Our ref: XA/2025/100350/05-L01
Your ref: EN020026
Date: 10 March 2026

ENVIRONMENT AGENCY RESPONSE FOR DEADLINE 5.

SEA LINK, EAST ANGLIA AND KENT

Plate 2.3 Infrastructure within fluvial flood extents

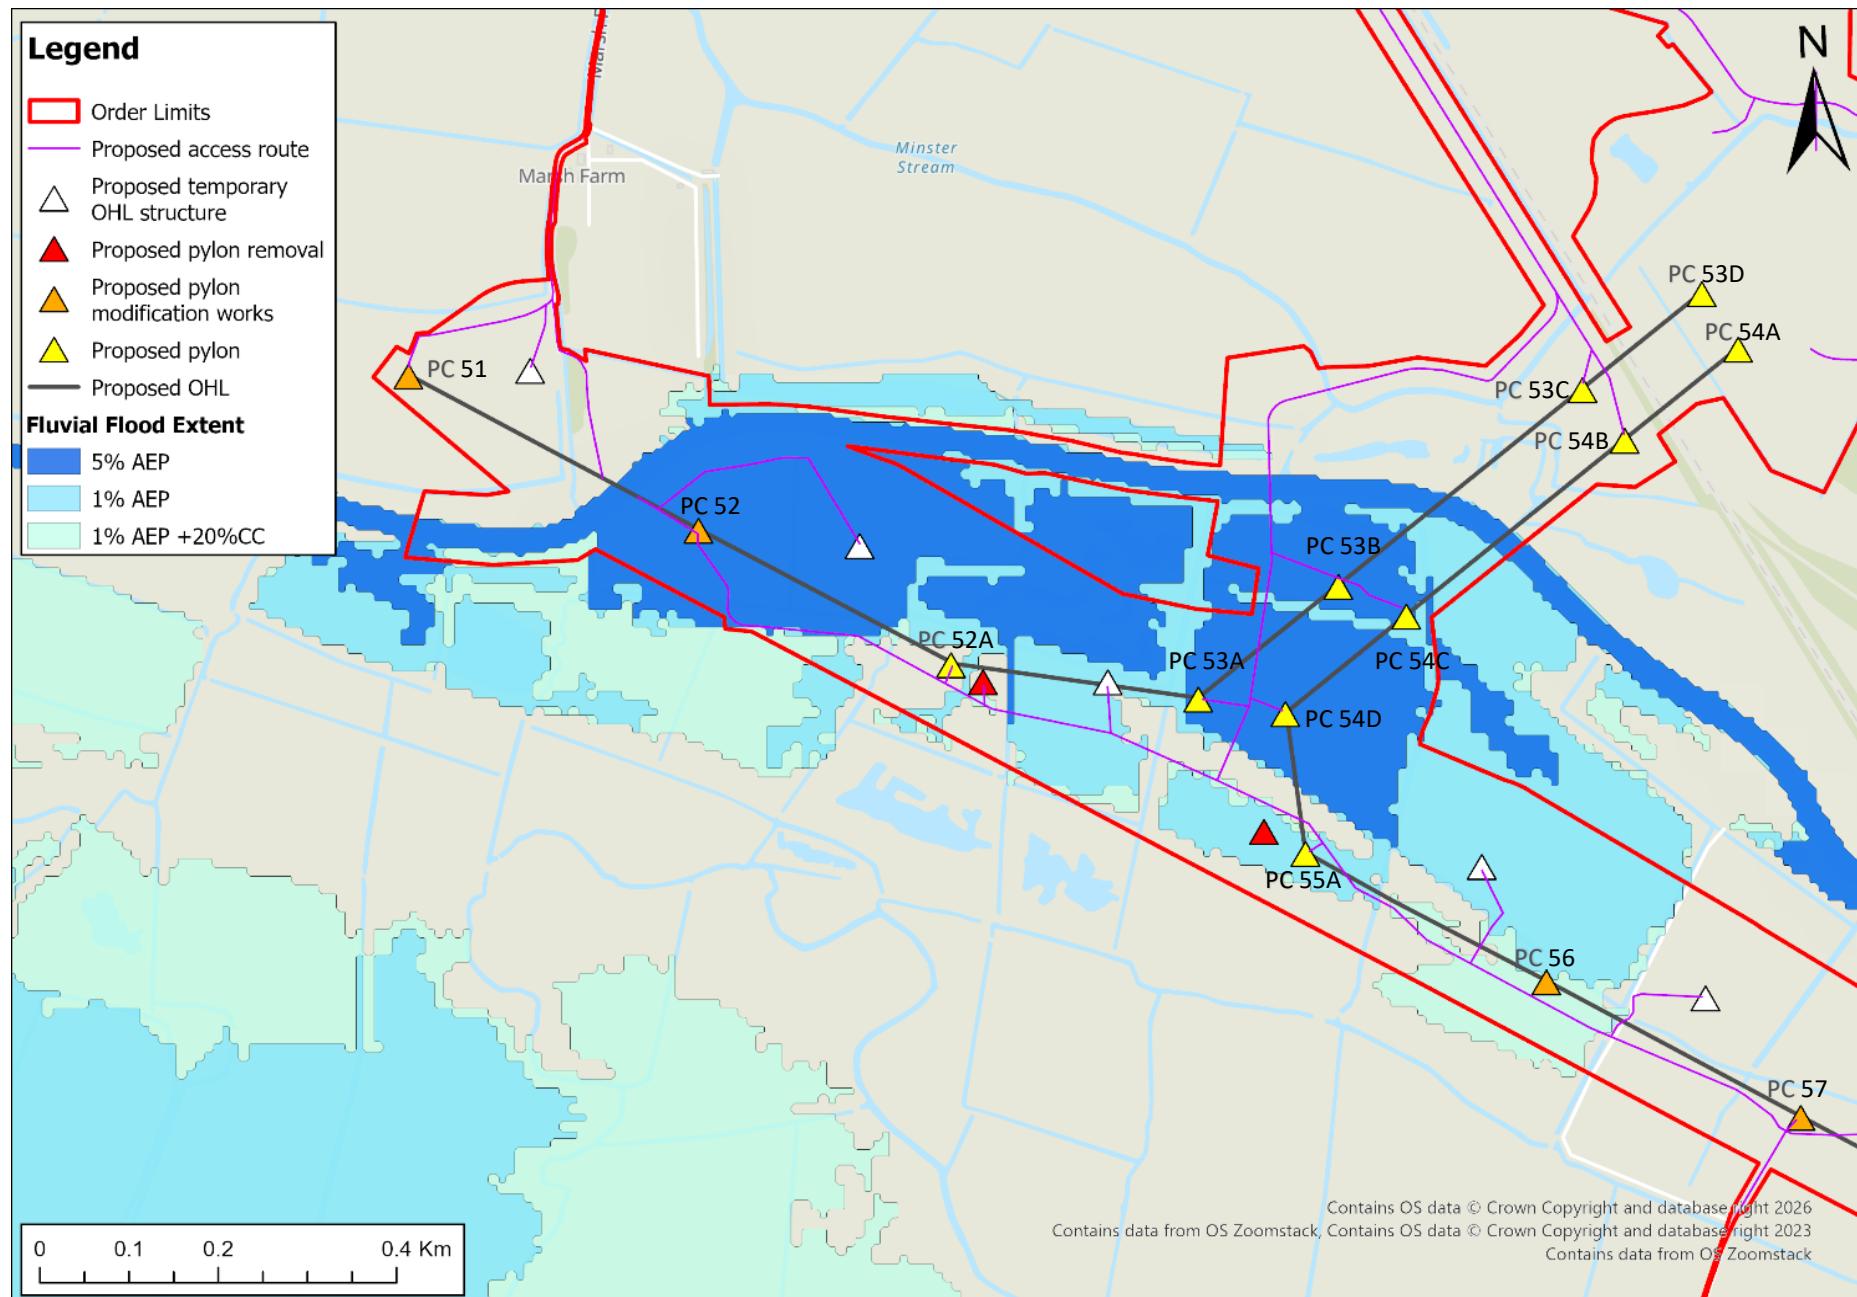
We welcome that the applicant has assessed the storage lost because of the pylon structures within the River Stour Floodplain (in Kent) and that the applicant has committed to compensatory storage for this.

We still require an assessment of the loss of floodplain storage and associated impact for the temporary attenuation pond 640430, 262030 in Suffolk and the temporary haul roads within the functional floodplain for the River Stour in Kent.

Plate 2.4 Potential floodplain compensation provision locations

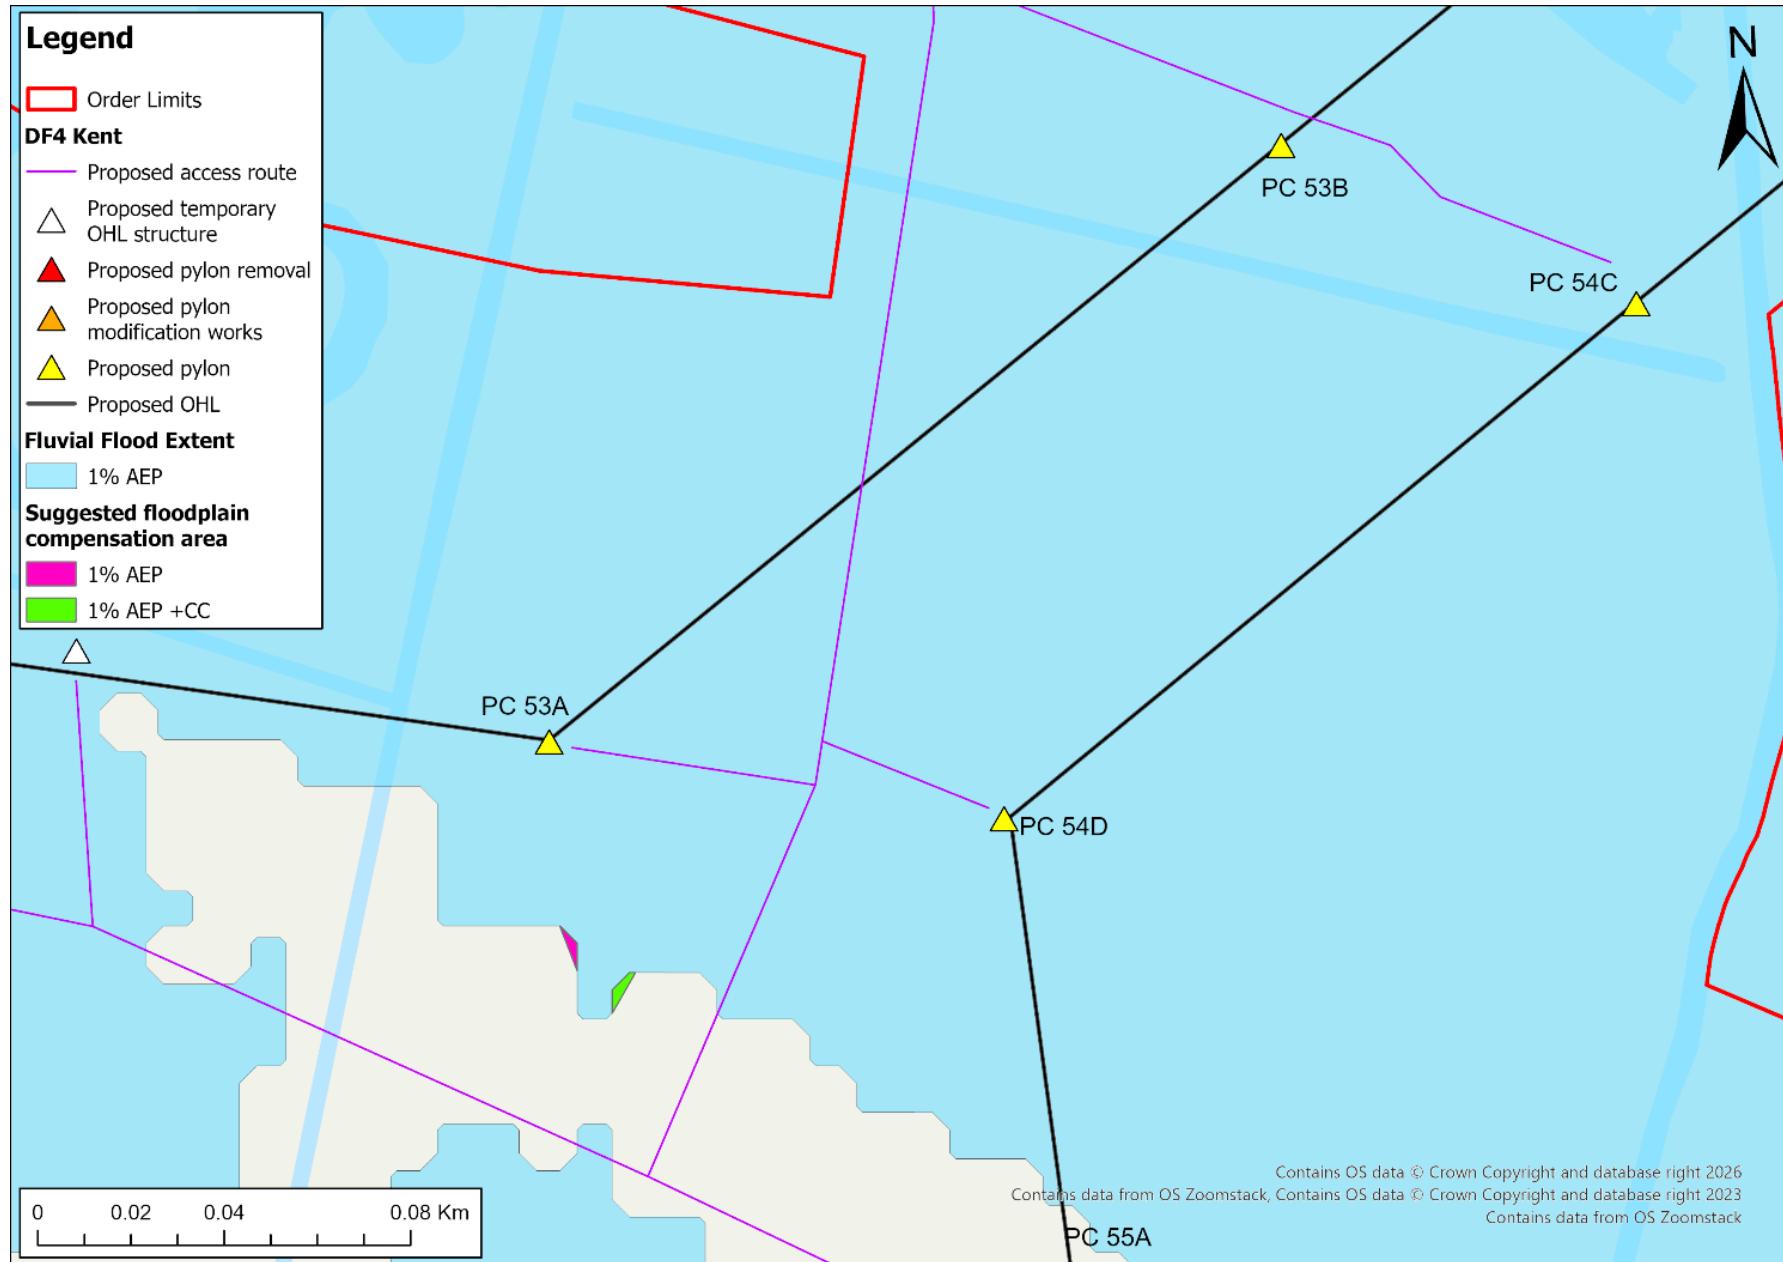
Document 6.8 Flood Risk Assessment [[APP 292](#)] has not yet been updated, however the applicant confirms within document 9.101: Kent Onshore Scheme – Fluvial Flooding from the River Stour [[REP4-096](#)] that they need to do compensation and that this mitigation “will be secured through the addition of a new commitment to the relevant control document (e.g. Application Document 9.84 Register of Environmental Actions and Commitments (REAC) [[REP3-078](#)]) at the next appropriate deadline”. This is welcome and we look forward to reviewing this.

We note the applicant has stated within Document 9.101: Kent Onshore Scheme – Fluvial Flooding from the River Stour [\[REP4-096\]](#) that we do not require compensation for temporary works. This is incorrect.
